State Significant Development Application and Variation of the Sydney Cove Redevelopment Scheme for the “*Remediation, Renewal and Adaptive Re-Use of Campbell's Stores*”, The Rocks (SSD 7056)

I write in response to the above development application (DA) and request to vary the Sydney Cove Redevelopment Authority Scheme (SCRAS) submitted to the Minister for Planning by Tallawolodah Pty Ltd for proposed works to the Campbell's Stores at The Rocks.

Drawing Title  
**HICKSON ROAD LEVEL 01 PLAN**  
Drawing Number  
**12006**  
Drawing Status  
**EA**  
Drawing Number  
**EA-A-1002**  
Revision  
**B**

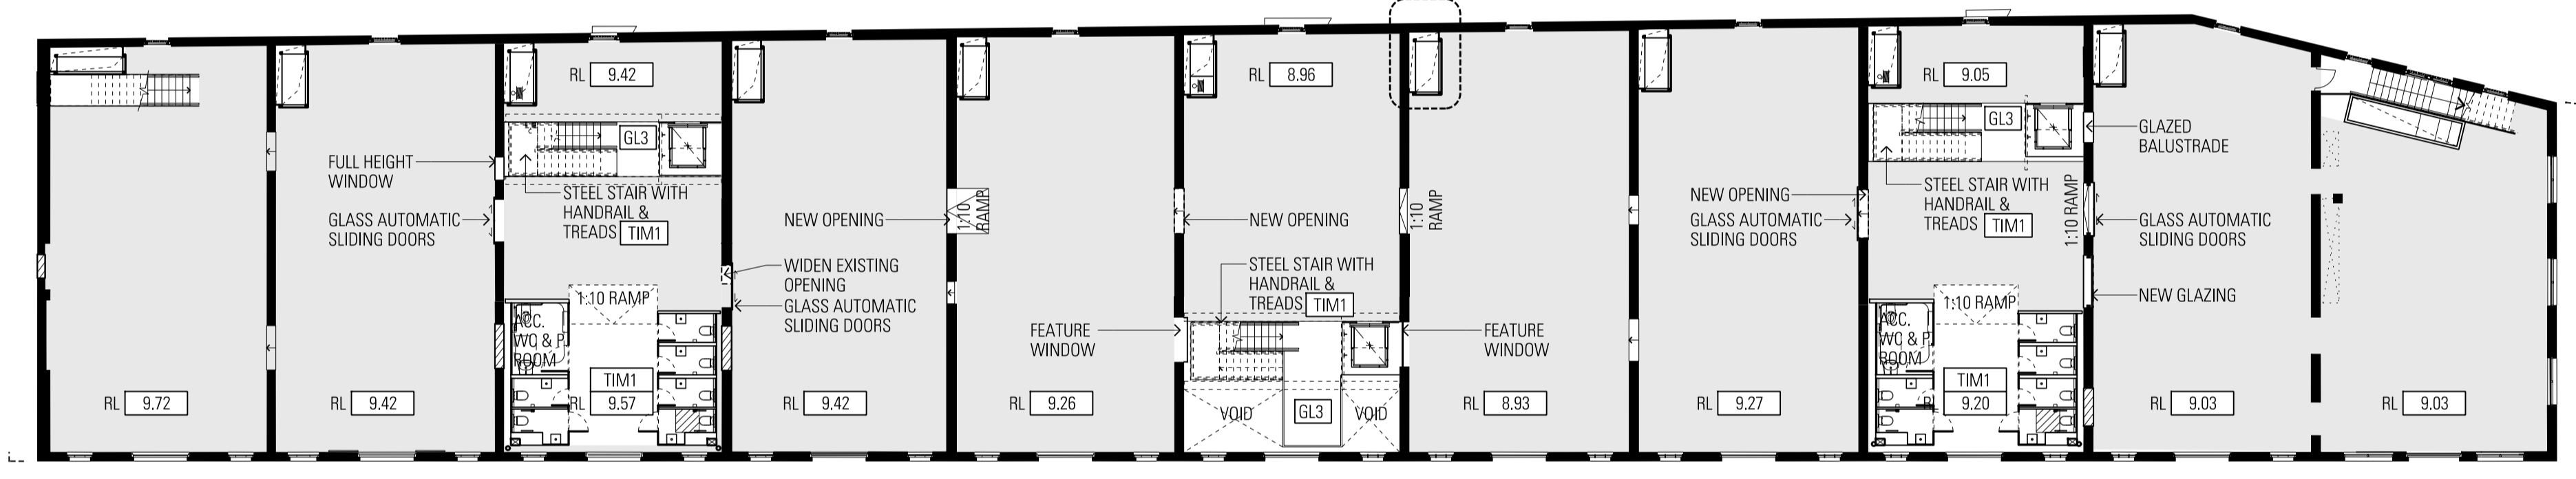
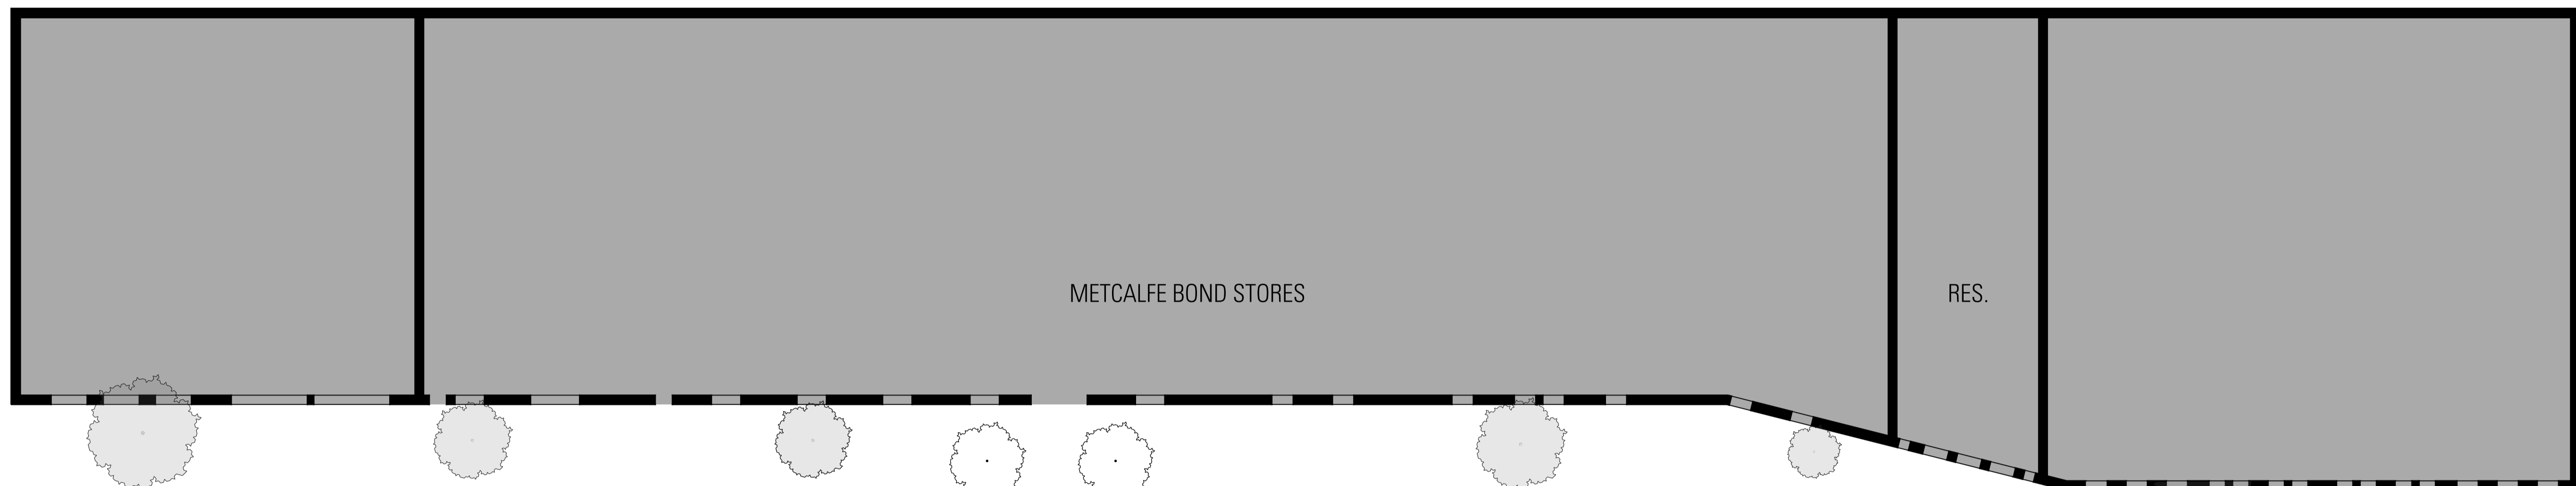
- There is no detailed description about works to Hickson Road, such as loss of on street car parking or specific details about outdoor seating and dining. The Hickson Road frontage of Campbell's Stores is the only elevation that remains visually uncluttered and relatively unaltered, retaining its simply detailed, 19th century industrial character and is an important component of the overall heritage significance of the place.

- The current proposal involves the introduction of new uses to the Hickson Road frontage. It involves unsympathetic alterations to existing openings including new concrete entry portals with back-lit signs and potentially the introduction of chairs and tables, umbrellas and street trees. The end result will be that the Hickson Road frontage will be cluttered, visually obscured and the ability understand the original form and use of this building of 'Exceptional' heritage significance will be reduced.

Drawing Title  
**ELEVATIONS**  
JPW Project Number  
12006  
Drawing Status  
EA  
Drawing Number  
EA-A-2000  
Revision  
B

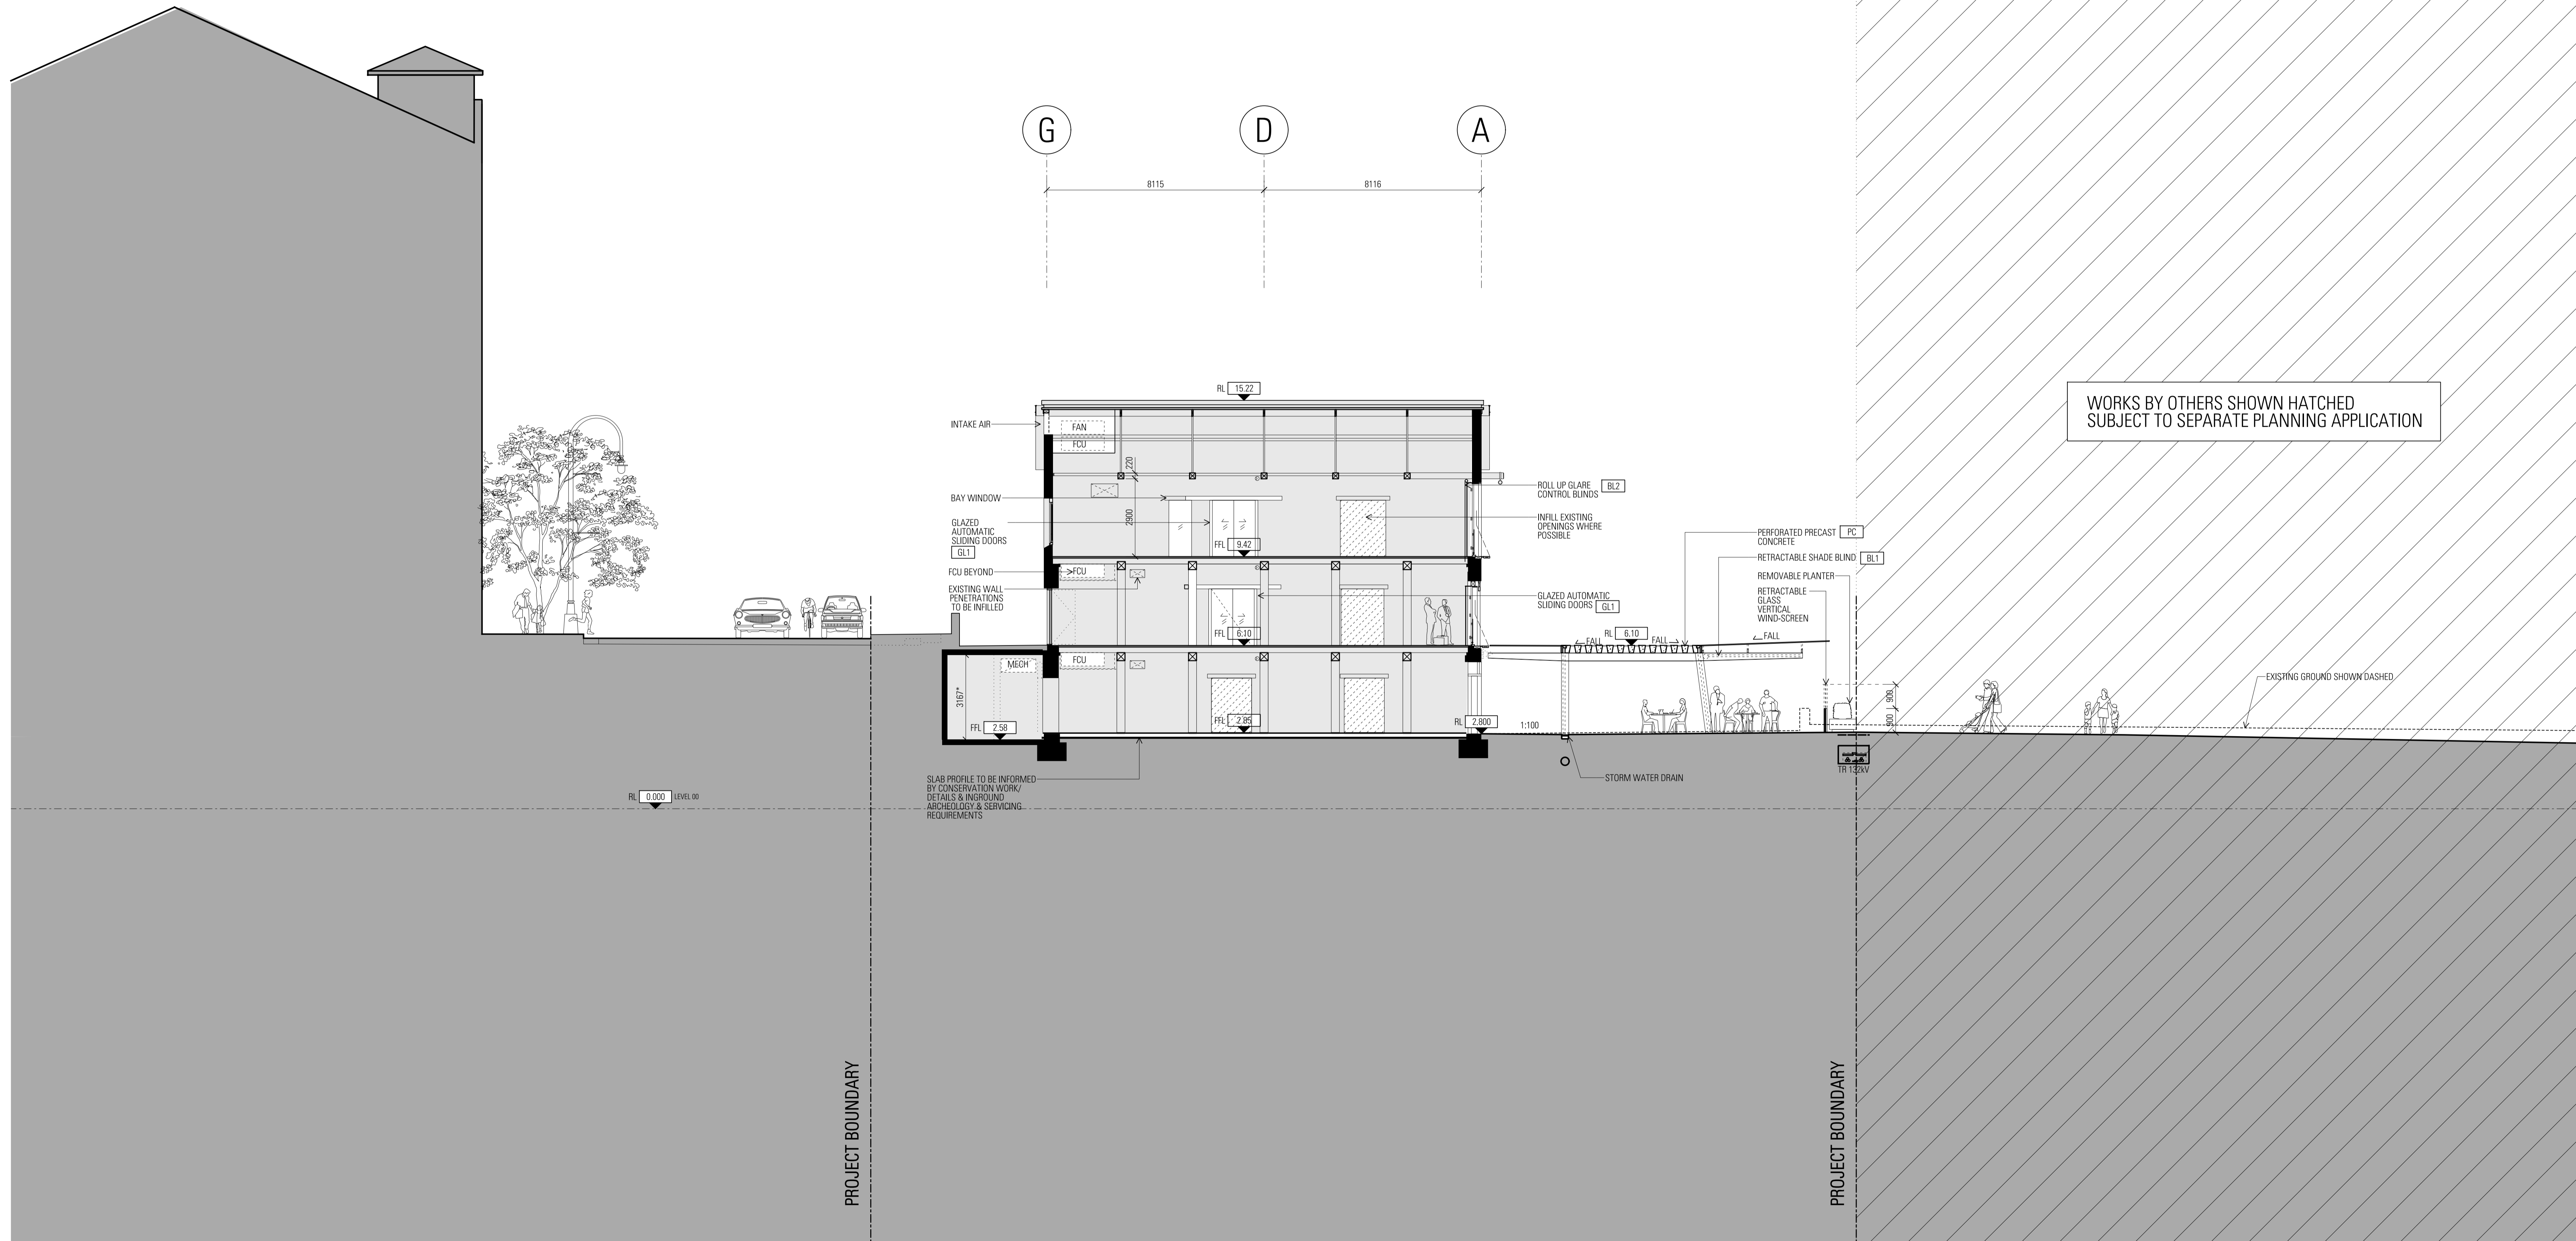
I object to the proposed development, particularly the appropriateness and design of a new four storey glass box to the north of the Campbell's Stores. This is an intrusive and ill-conceived structure that will have negative visual impact and result in the loss of public open space. The proposed new four storey glass building is out of context, dwarfs the heritage building and will be the tallest built element along this promenade. It is located within the buffer zone of the World Heritage Listed Sydney Opera House.

- The proposed new glass building does not comply with the current height limit and the applicant has applied for a "spot rezoning" to increase the height along the waterfront by more than five times the current permissible height limit - from RL3.5 to RL18.

- The proposal exceeds the height restriction on the foreshore **frontage by 14.5m, more than 250% and on the Hickson Road elevation by 10.5m, or 140%.**
